# Rezoning Transportation Analysis

Petition Number: 2019-180

**From:** Felix Obregon, PE  
[fobregon@charlottenc.gov](mailto:fobregon@charlottenc.gov)  
704-432-5729

Date	Description
01-14-2020	First Review
02-11-2020	Second Review

**RZ-2.0**

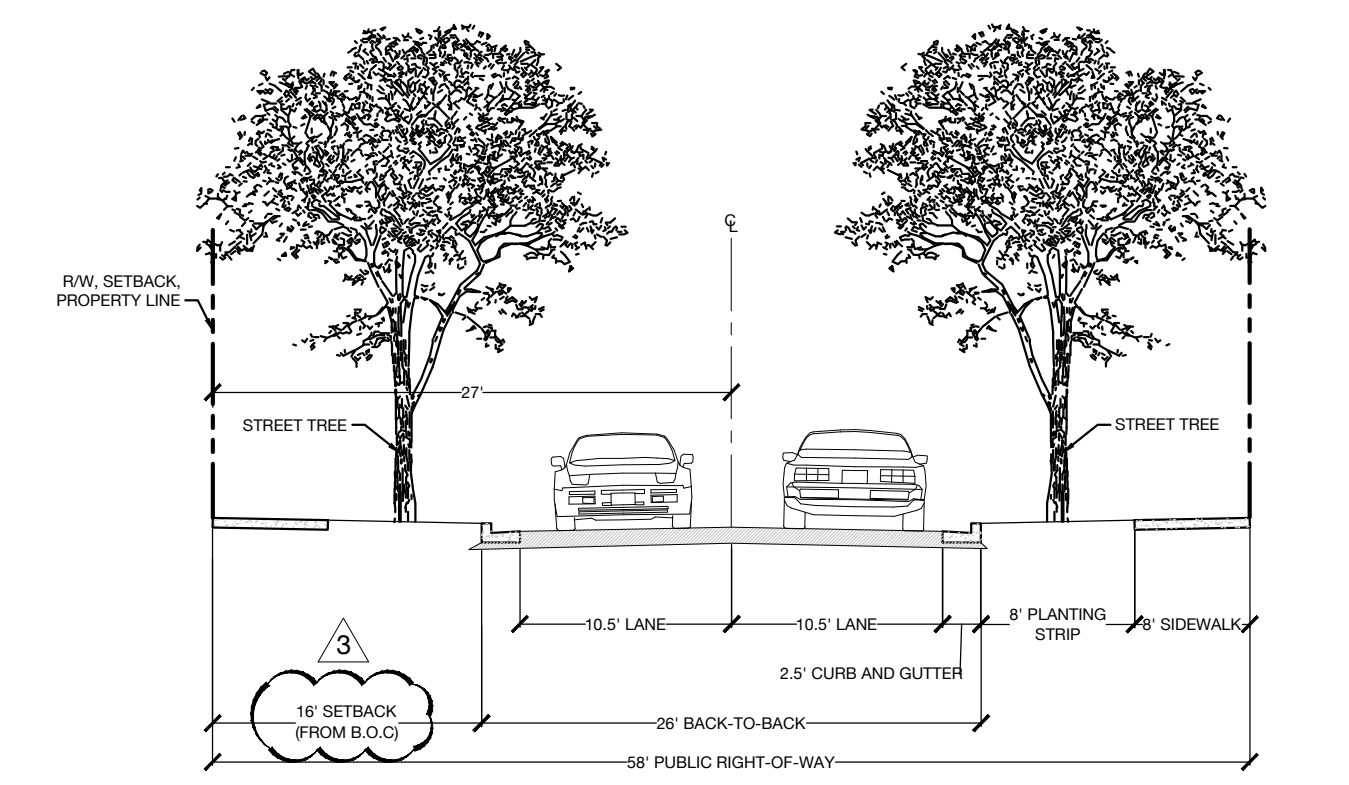
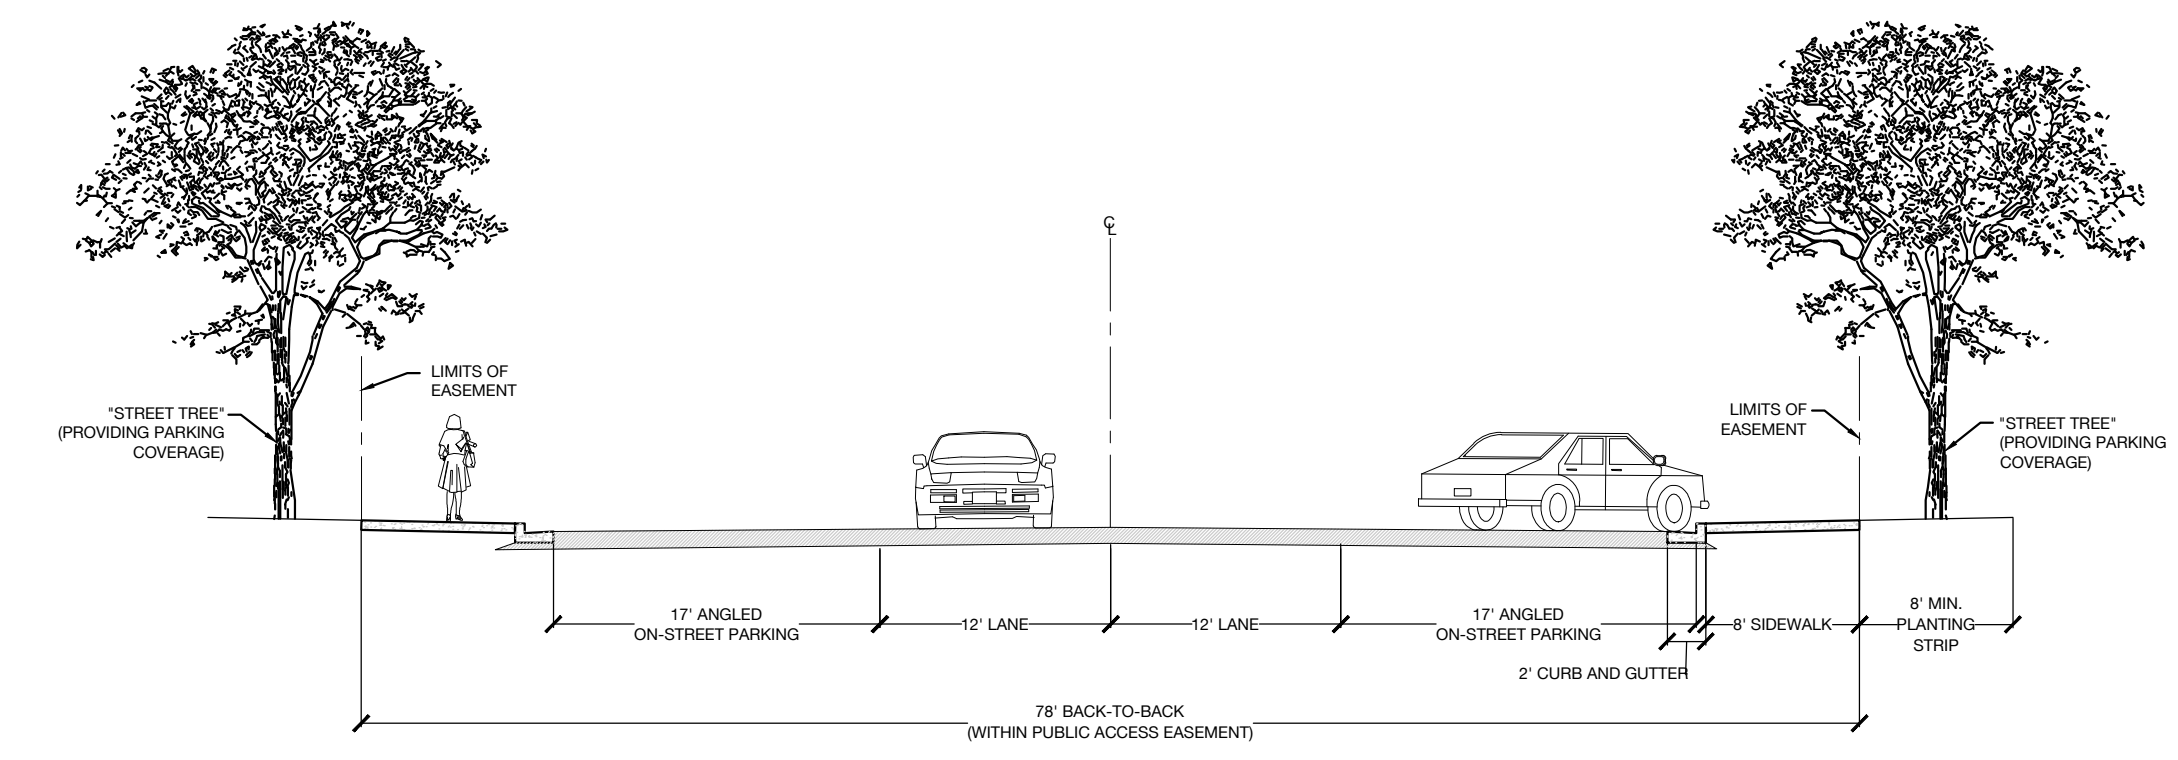
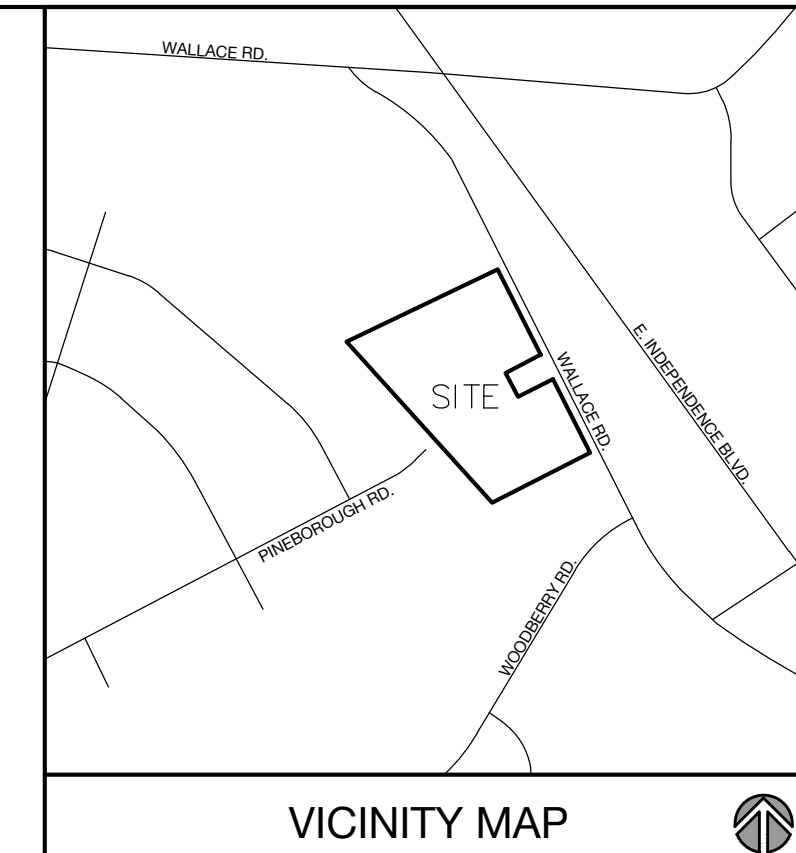
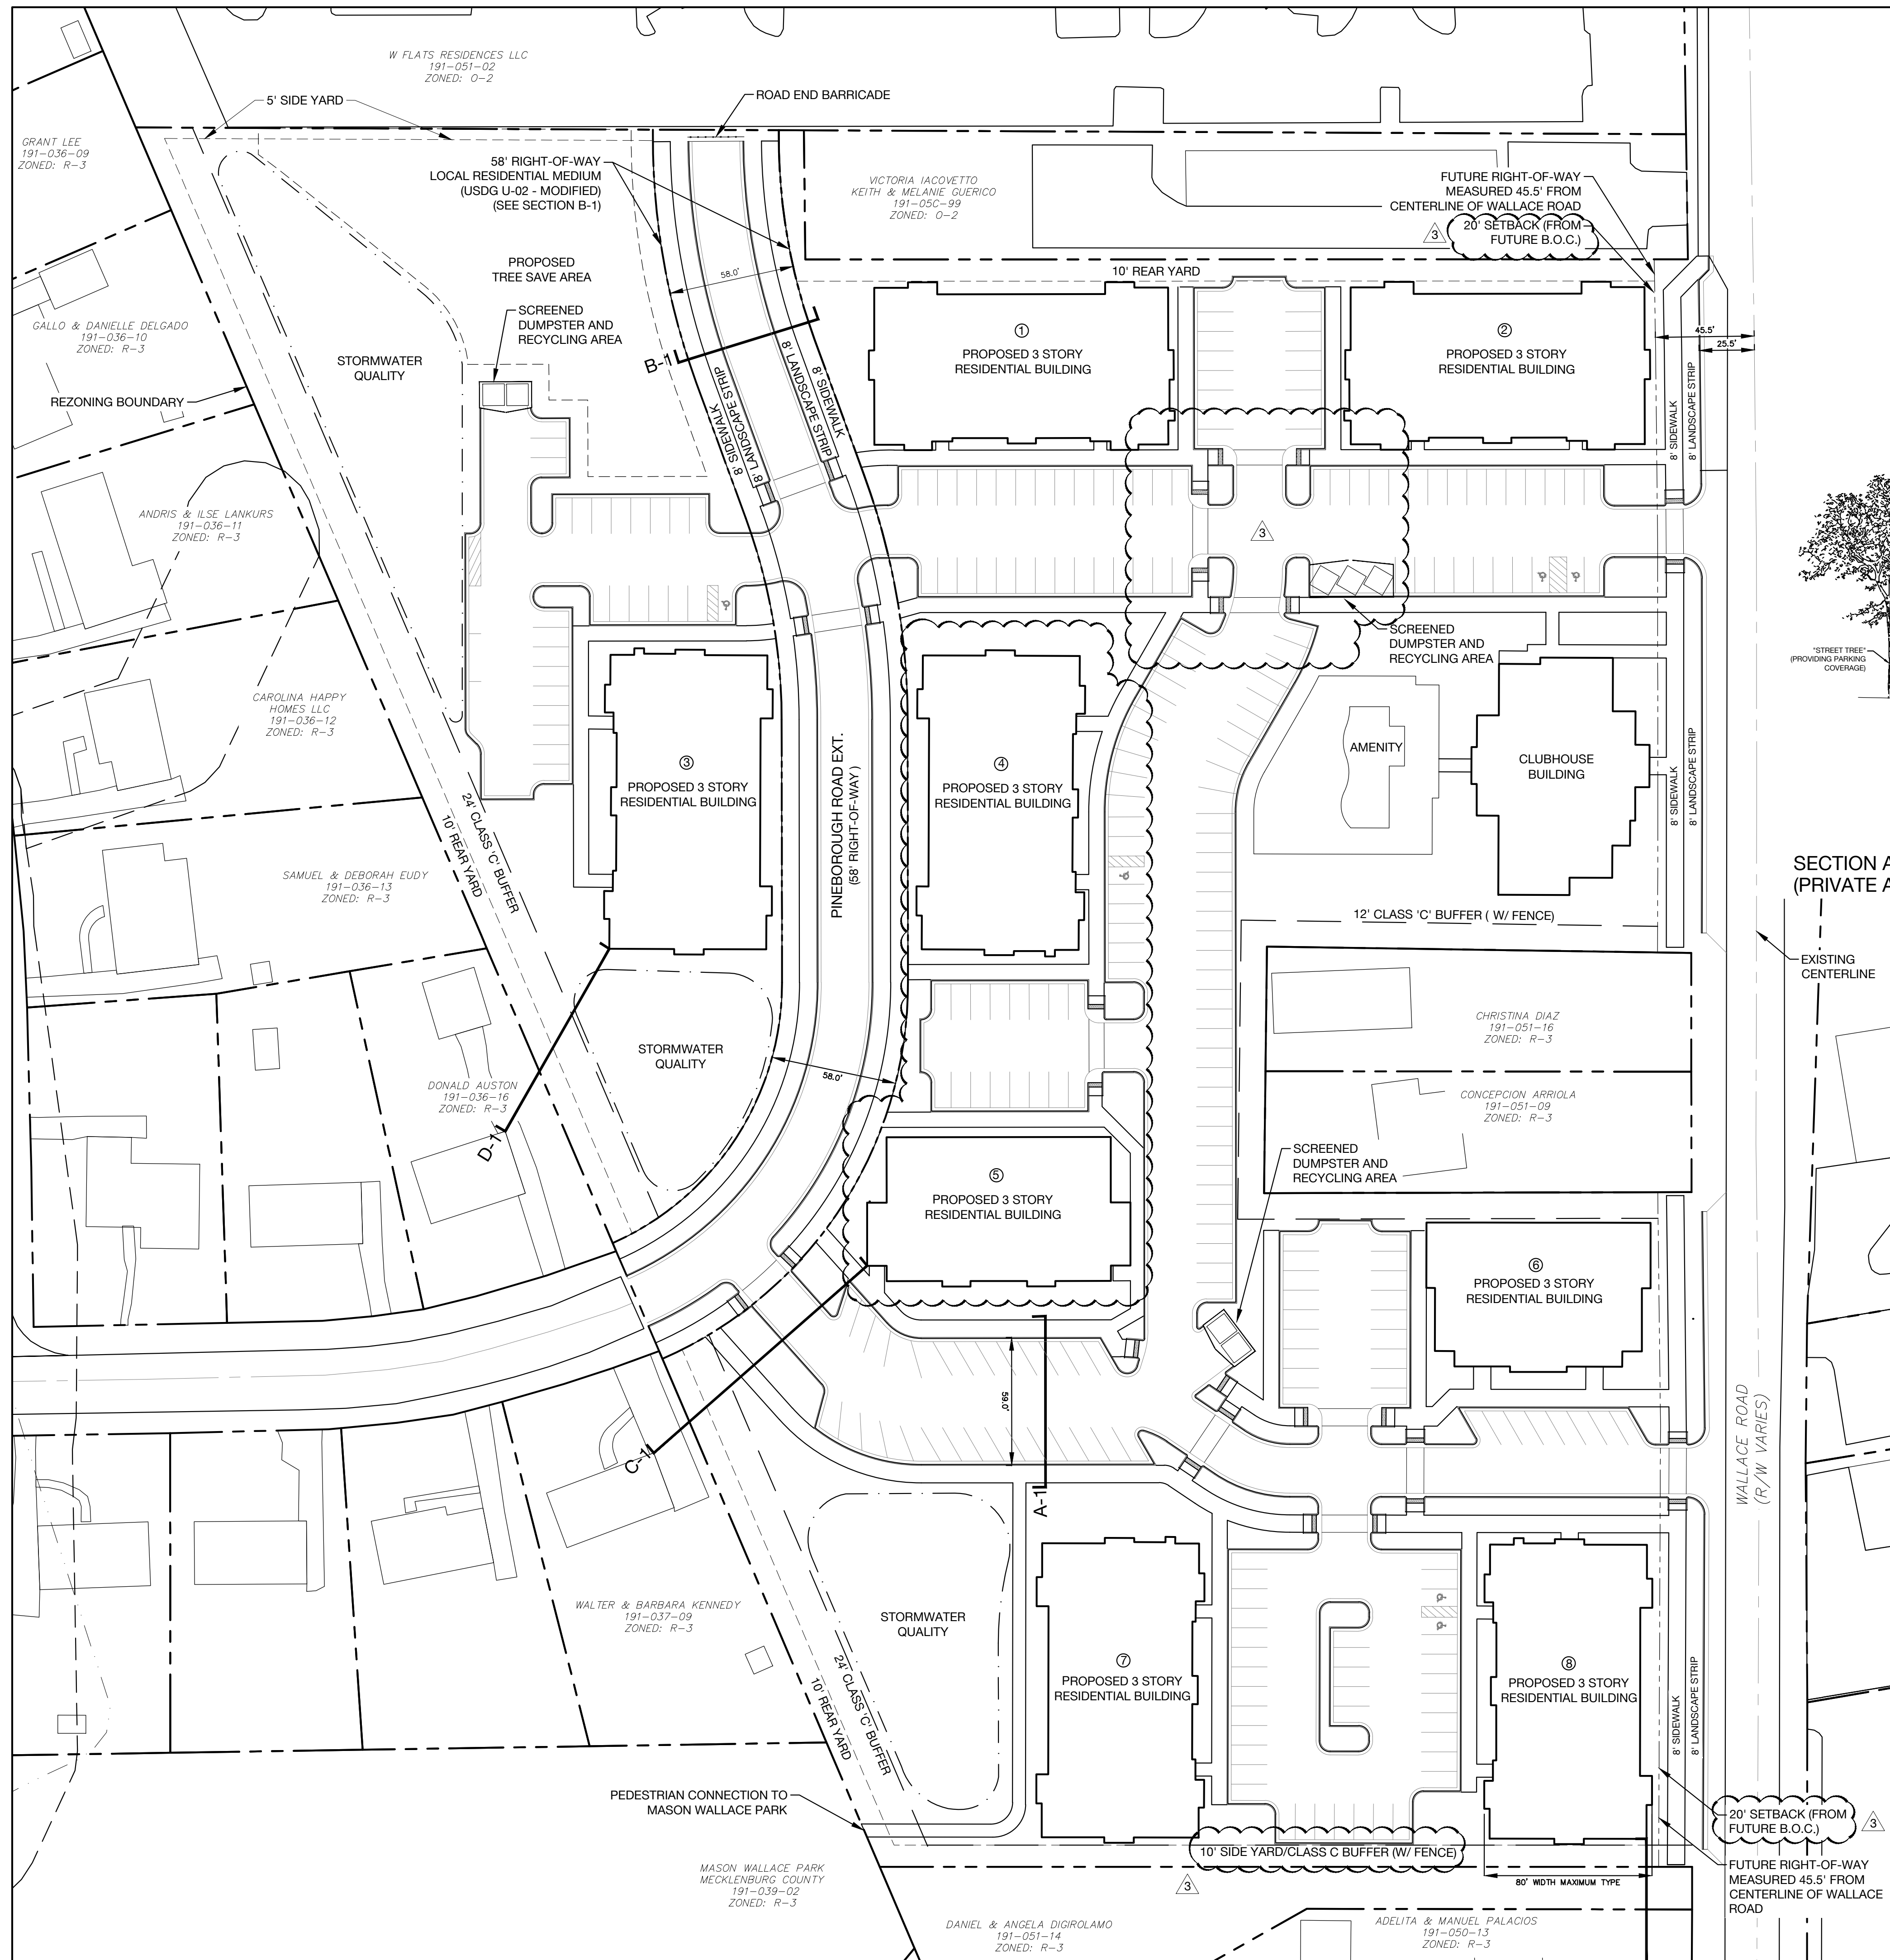
1. **Curbline** The proposed zoning district has a setback measured from back of the existing or proposed future curbline.
  - a. **Wallace Road:** The proposed back of curb is 25.5' from the centerline of Wallace Road including half the 12' median, 11' travel lane, 6' bike lane, 2.5' curb and gutter, 14' planting strip, and 6' sidewalk.
  - b. **Pineborough Road:** The cross section the petitioner has provided, 58' from back of sidewalk to back of sidewalk, is sufficient.

The site plan should show the curb and gutter labeled and dimensioned from the centerline for each road.

2. ~~**Traffic Study** A Traffic Impact Study is not necessary for the complete review of this petition.~~
3. Chapter 19 Ordinance requires the curb and gutter be constructed in its future location. The petitioner should continue the existing curb and gutter on Wallace Road.

5. The petitioner should remove the language from Transportation Note 7 that only refers to the sidewalk and ramps.
6. The petitioner should revise the site plan and conditional note(s) to show the recycling/dumpster area will occur on the eastern portion of the site plan (east of Pineborough Rd Extension).

7. The petitioner should revise the site plan to add a note specifying dedication and fee simple conveyance of all rights of way to the City before the site's first building certificate of occupancy is issued. CDOT requests right of way set at 2' behind back of sidewalk where feasible.
